Our Ref: BE/8/20/NMA

Non-material amendment following grant of reference BE/74/18/PL for various external and internal amendments (1 - 8)

1 Finch Gardens Bersted PO22 9EQ

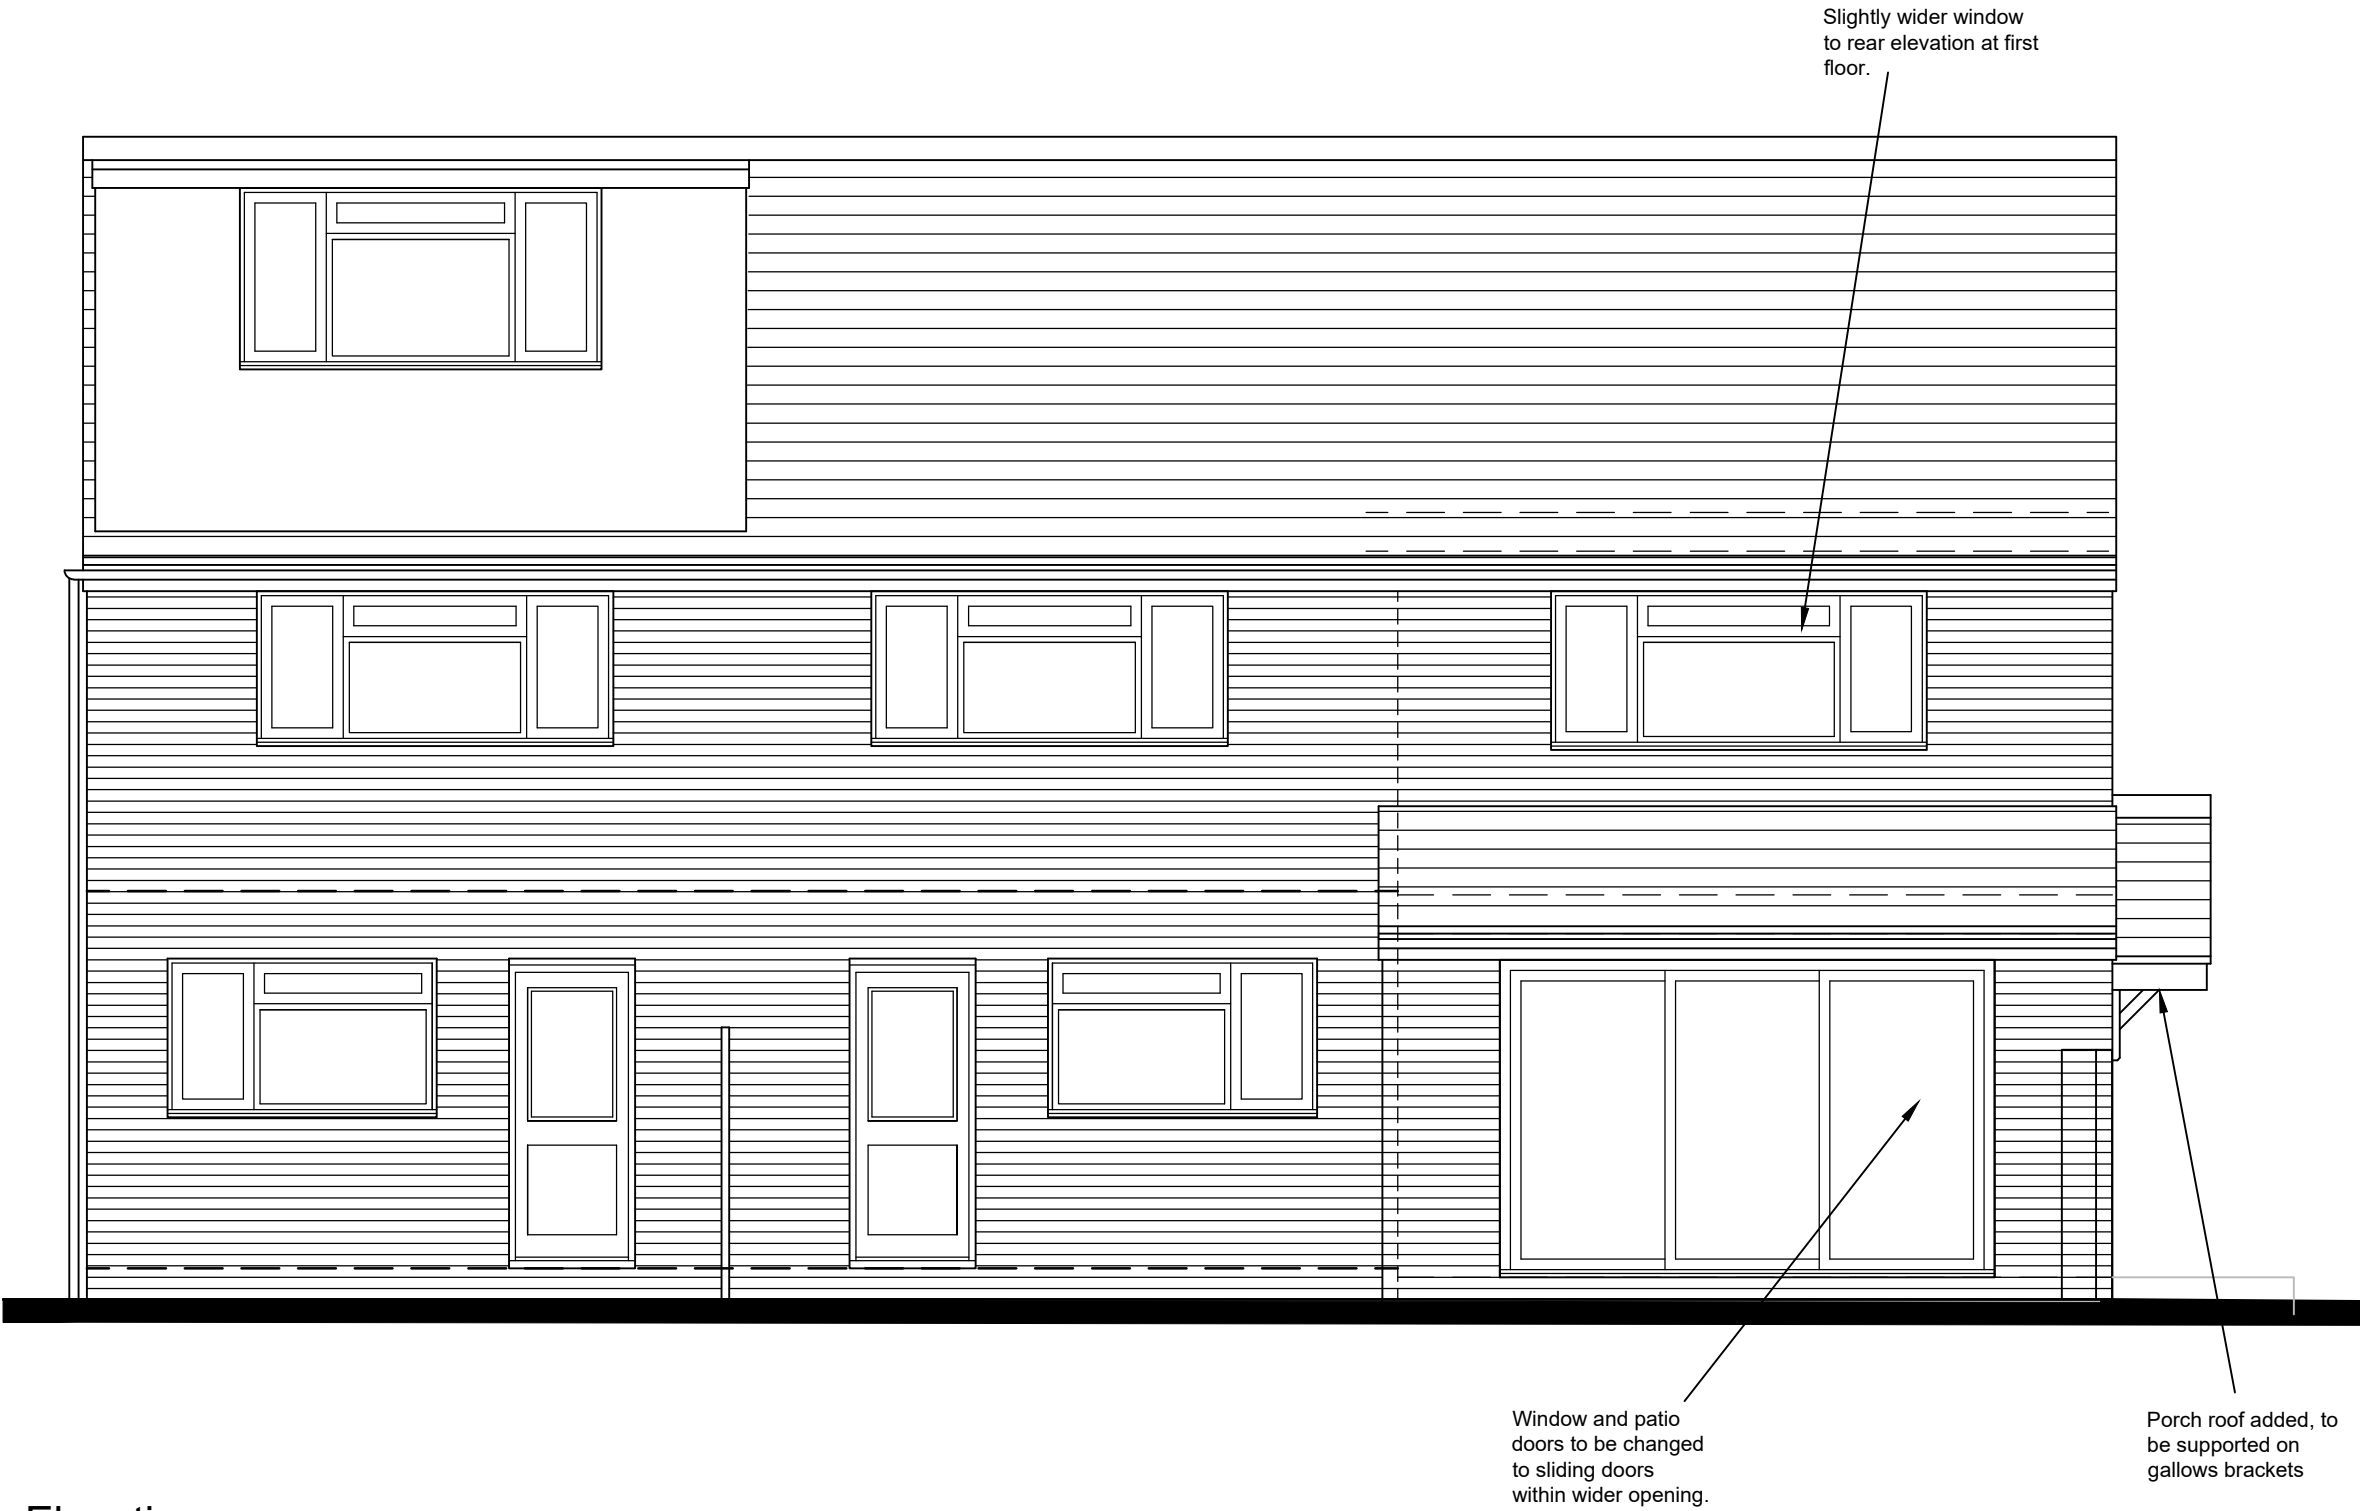
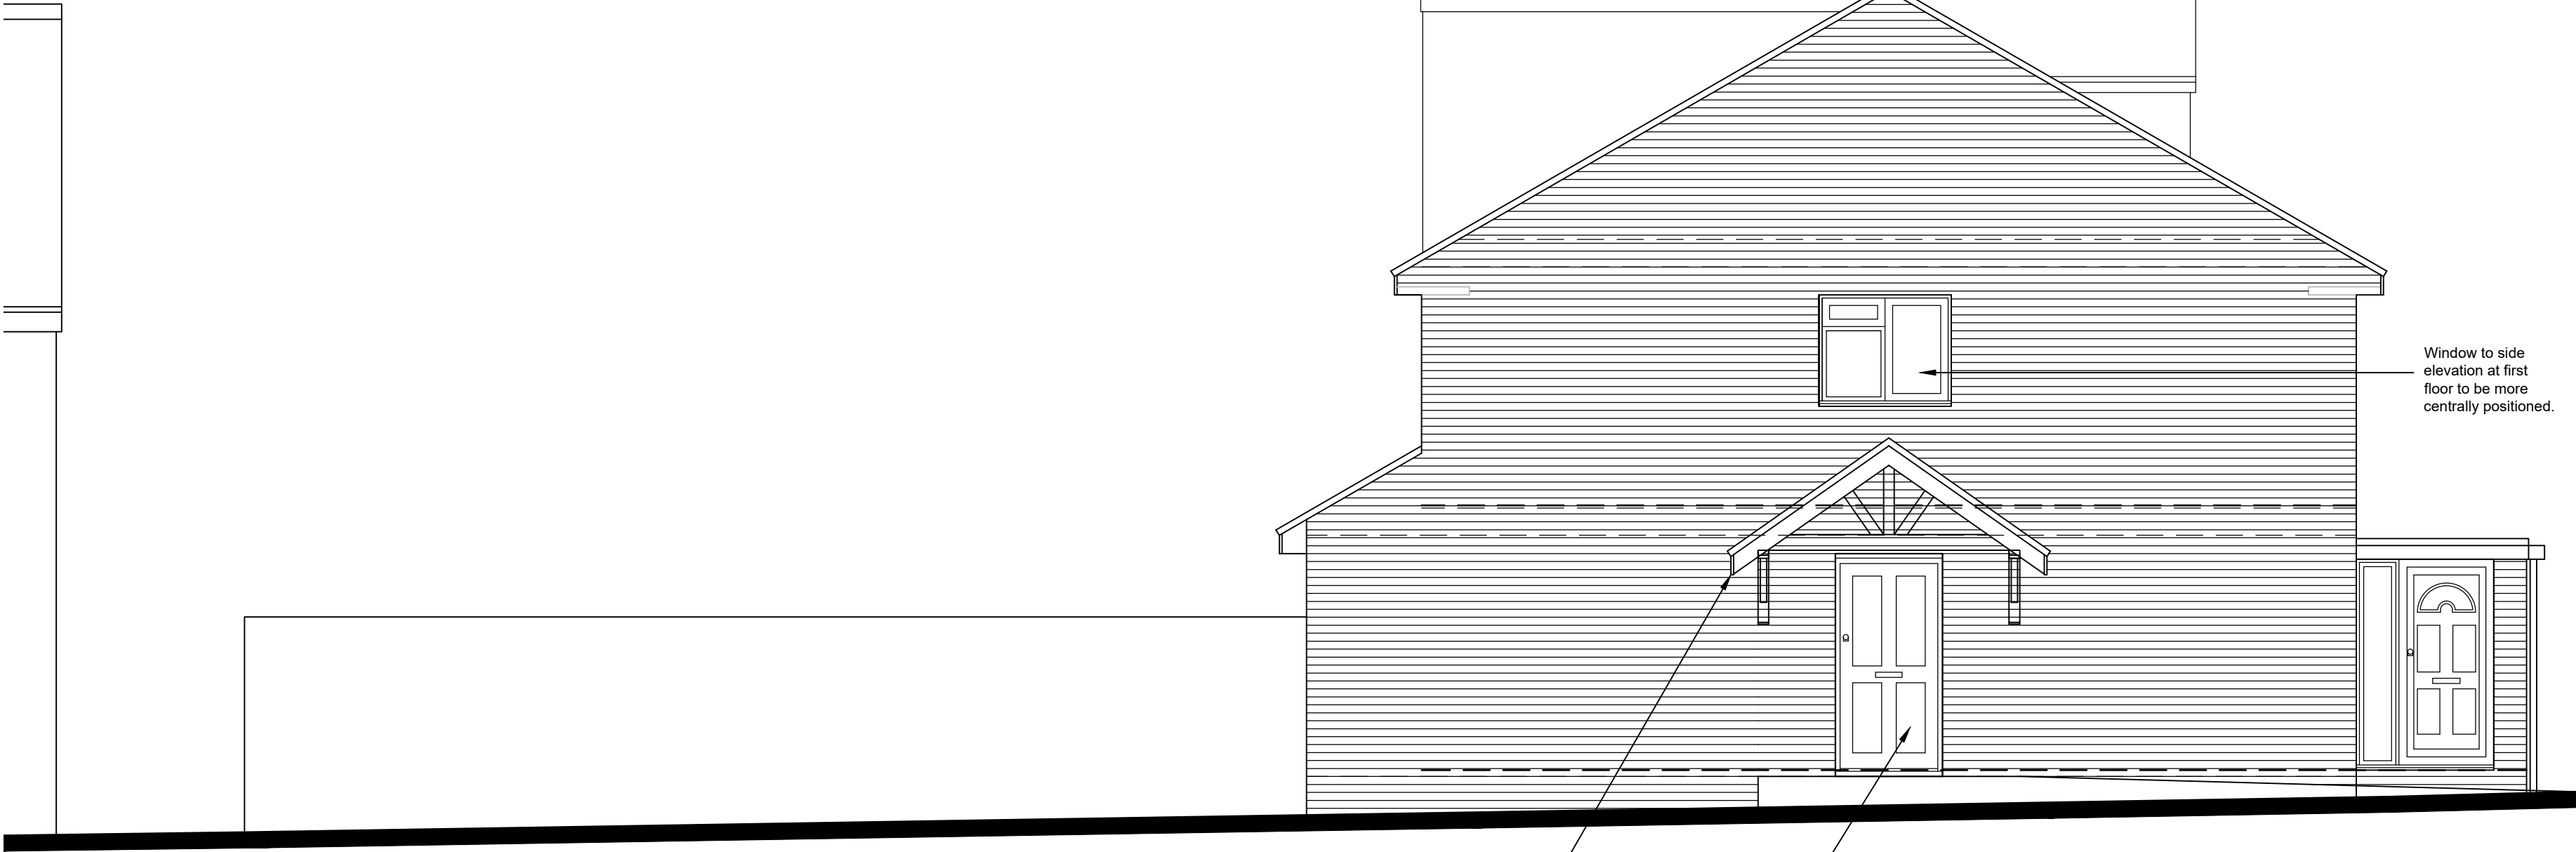
- (a) Front door moved to side of house and new porch roof canopy supported on gallows brackets and new path provided.
- (b) Windows on front elevation decreased slightly in width and centred.
- (c) First floor window on side elevation centred.
- (d) First floor window on rear elevation to be made slightly wider.
- (e) Ground floor door and window on rear elevation to be replaced with sliding doors within a wider opening.
- (f) Short side wall to rear projection to be moved away from existing house by approx. 20mm, so that its foundation can be 500mm clear of public sewer manhole.
- (g) The ground floor rear wall has been moved out by 25mm, so that the long side wall of the house works to brick dimensions.
- (h) Internal layout altered.
